KIRKLEES METROPOLITAN COUNCIL INVESTMENT & REGENERATION SERVICE

DELEGATED DECISION TO DETERMINE PLANNING APPLICATIONS

Reference No:	2024/62/93511/W
Site Address:	11, Basil Street, Crosland Moor, Huddersfield, HD4 5DP
Description:	Erection of single storey side and front extension
Recommending Officer:	Joshua Merriman

HOUSEHOLDER DELEGATED REPORT

Proposed Floor Plans

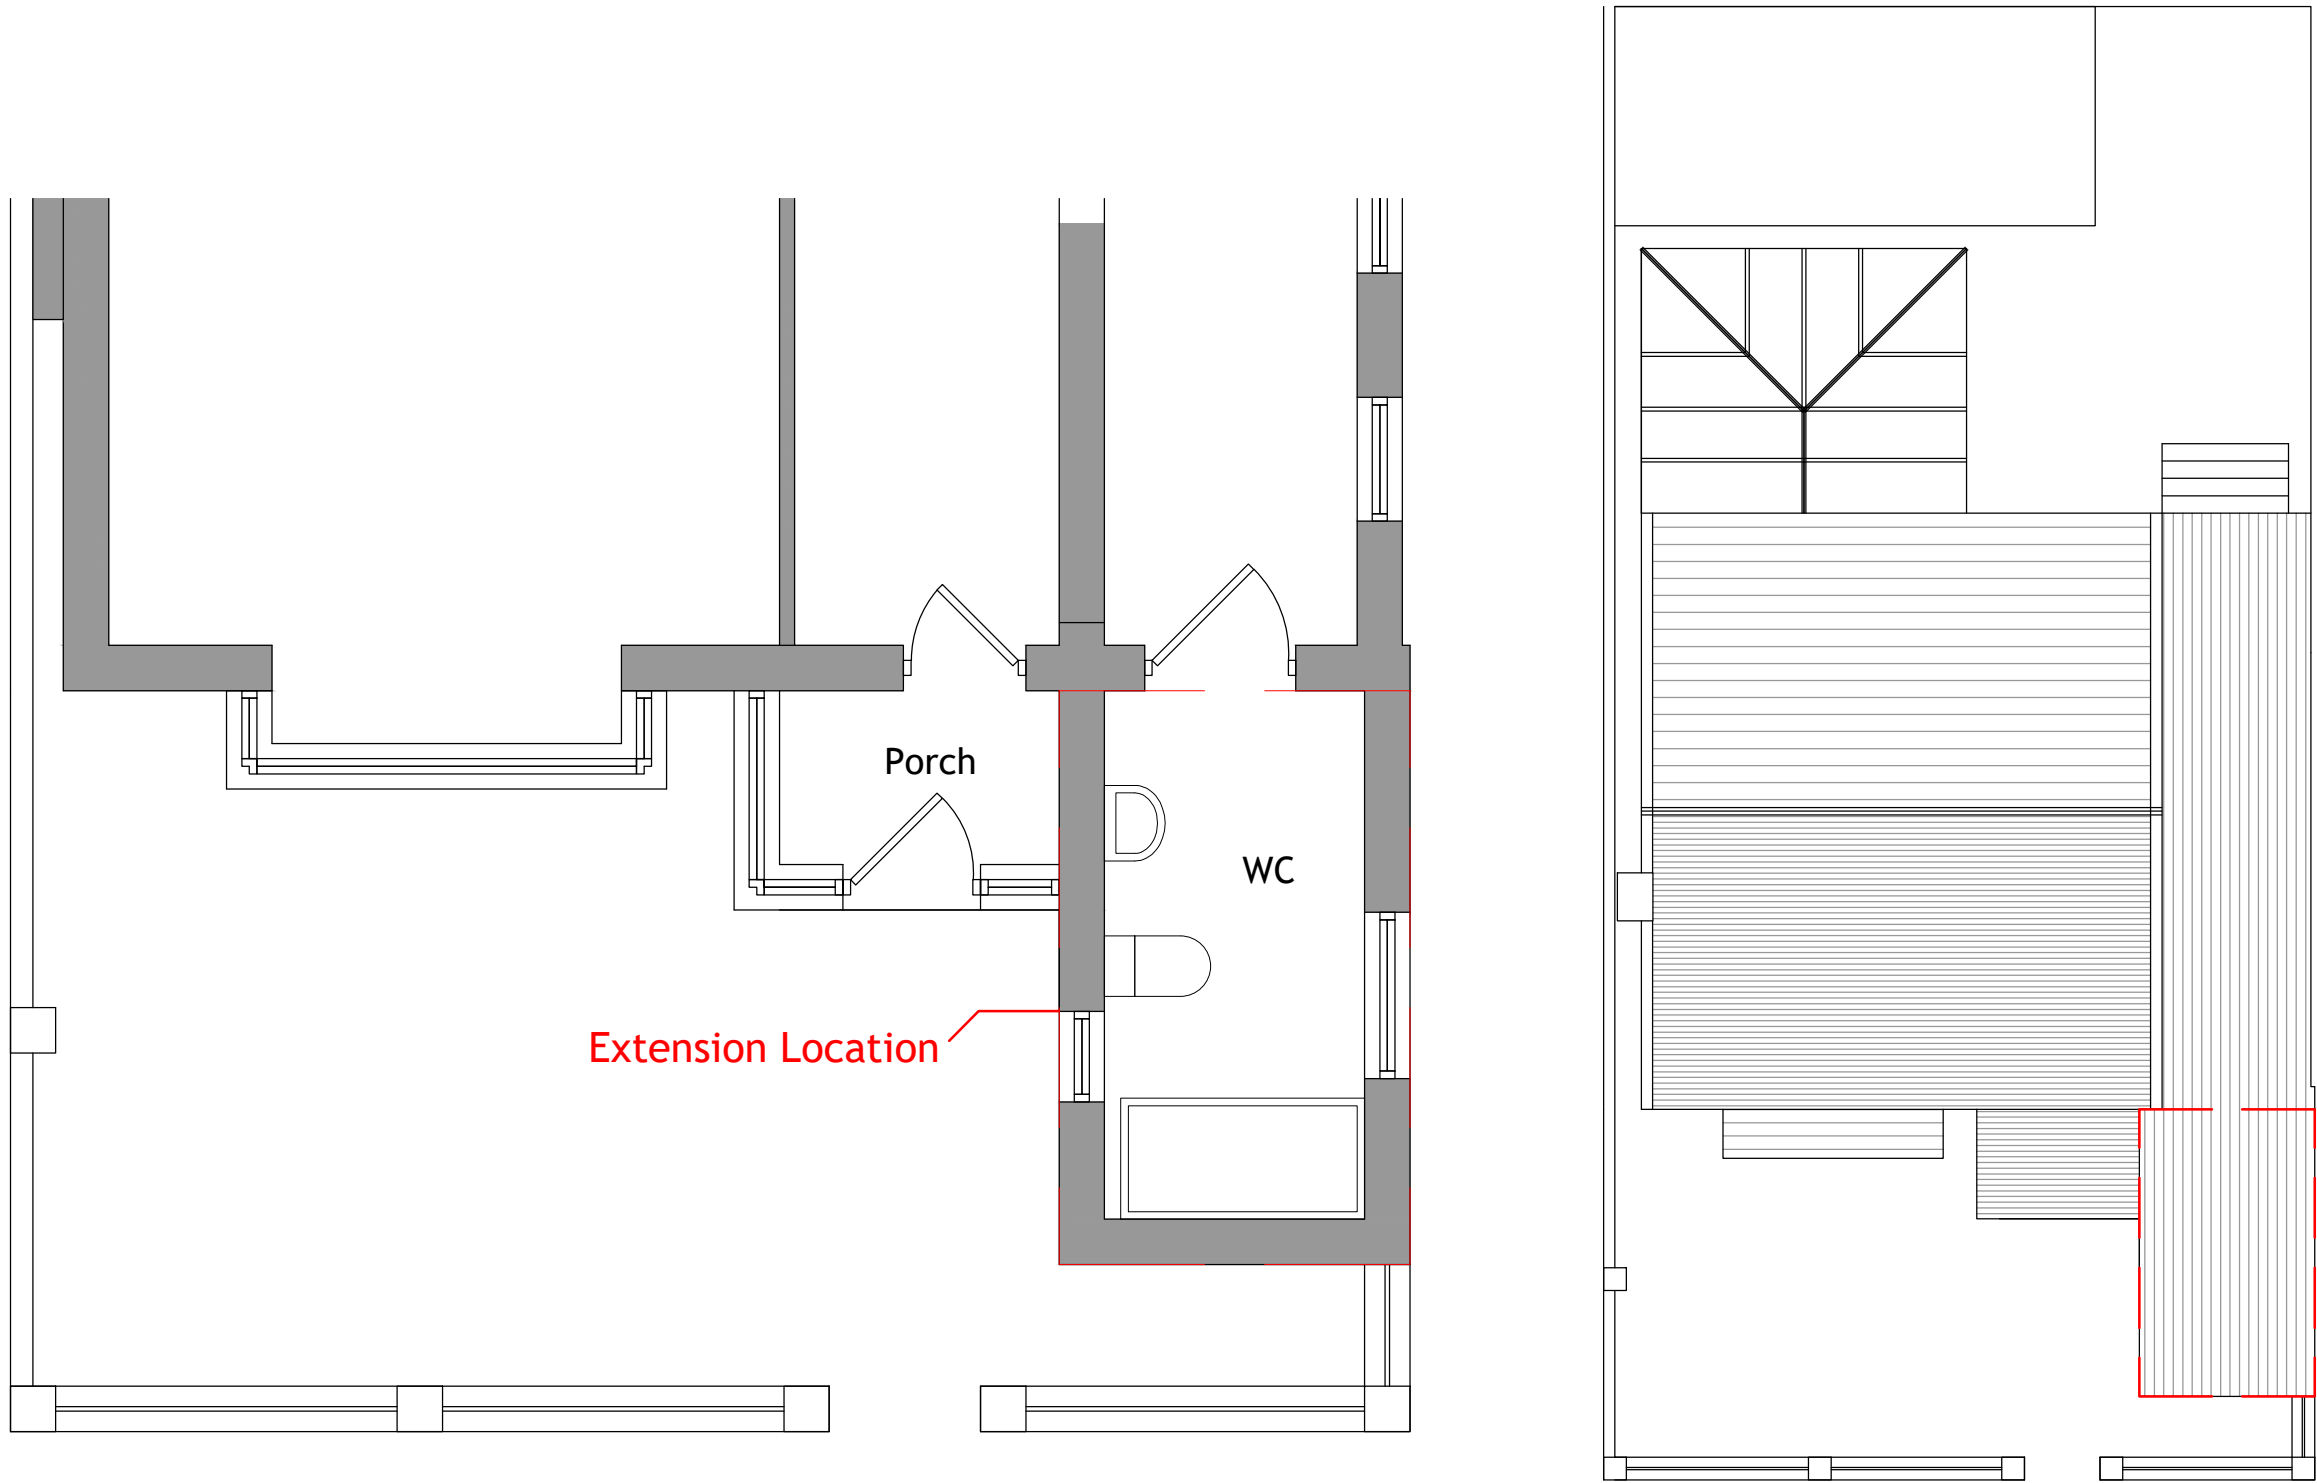
The proposed extension projects 3.8m from the front elevation of the existing building, with a maximum height of 2.91m, eaves height of 2.13m, and a width of 2.32m.

be set back at least 500mm from the original building line to allow for a visual break		The extension does project 3.8m from the front elevation of the existing building, rather than being set back. However, as there is no

The proposal is not set well back from the street and is a size and scale which does not meet the requirements of the House Extensions and Alterations SPD in this case. Therefore, in the absence of justification it is considered the development could not be considered to have an acceptable visual impact.

In this case the site specific circumstances are considered to be such that, whilst the proposal is of a size and scale and proximity to the street which may not be considered acceptable in other instances, it is considered the impact could not be considered so significant as to warrant refusal in this case.

On balance it is considered that refusal in this case could not be substantiated and the visual impact of the development within the street does not lead to a degree of harm which is so significant as to warrant refusal taking account of the factors which weigh in favour of justifying the development.

South East Elevations (Side) 1.100

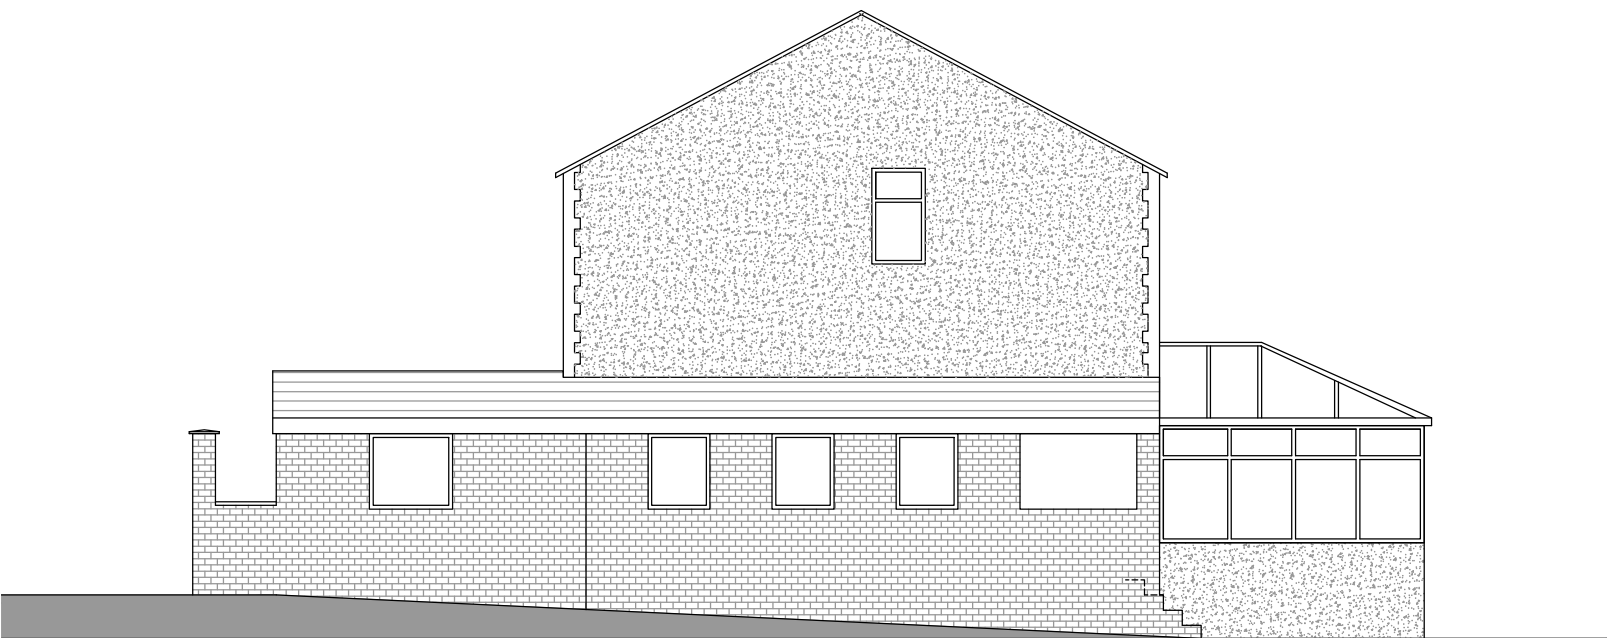
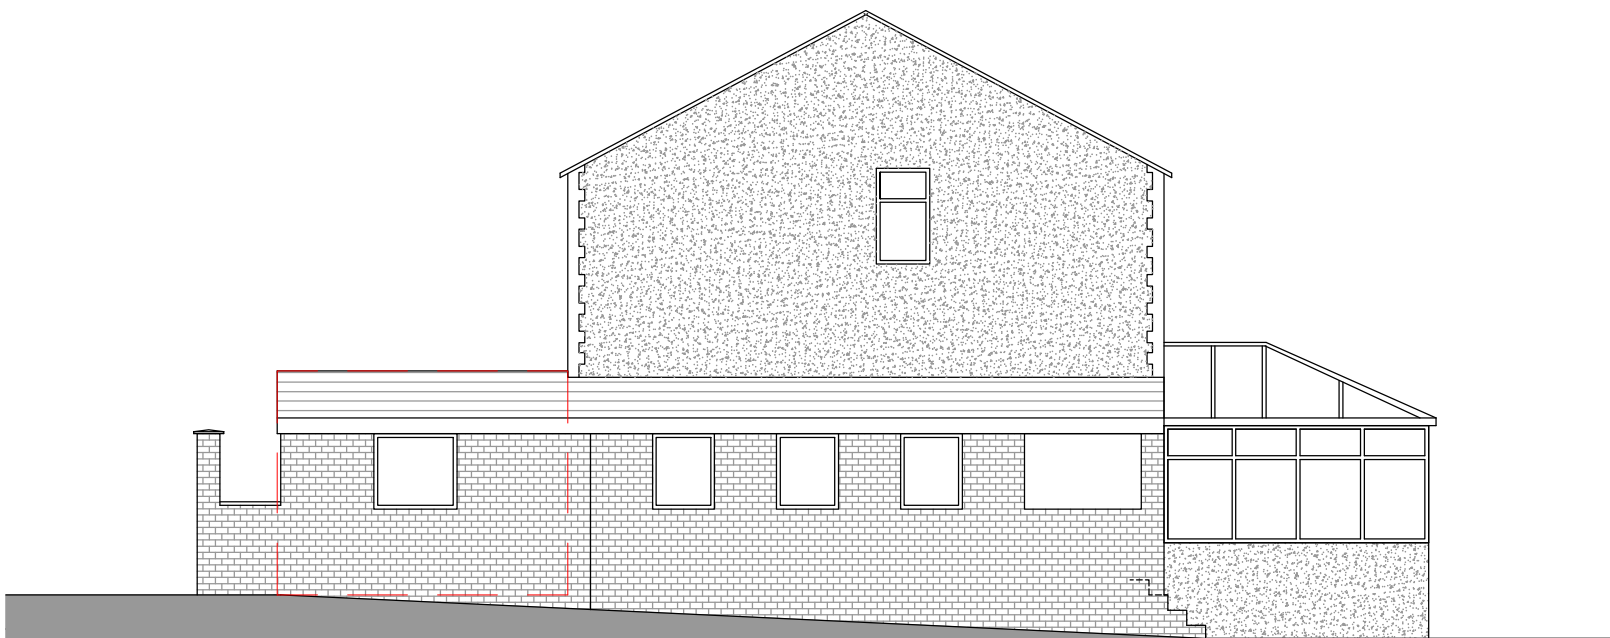
3. The window in the South East elevation shall be fitted with obscure glazing to at least Level 3 on the Pilkington Scale (or equivalent) and be non-opening to a height of no less than 1.7m above floor level and retained as such thereafter.
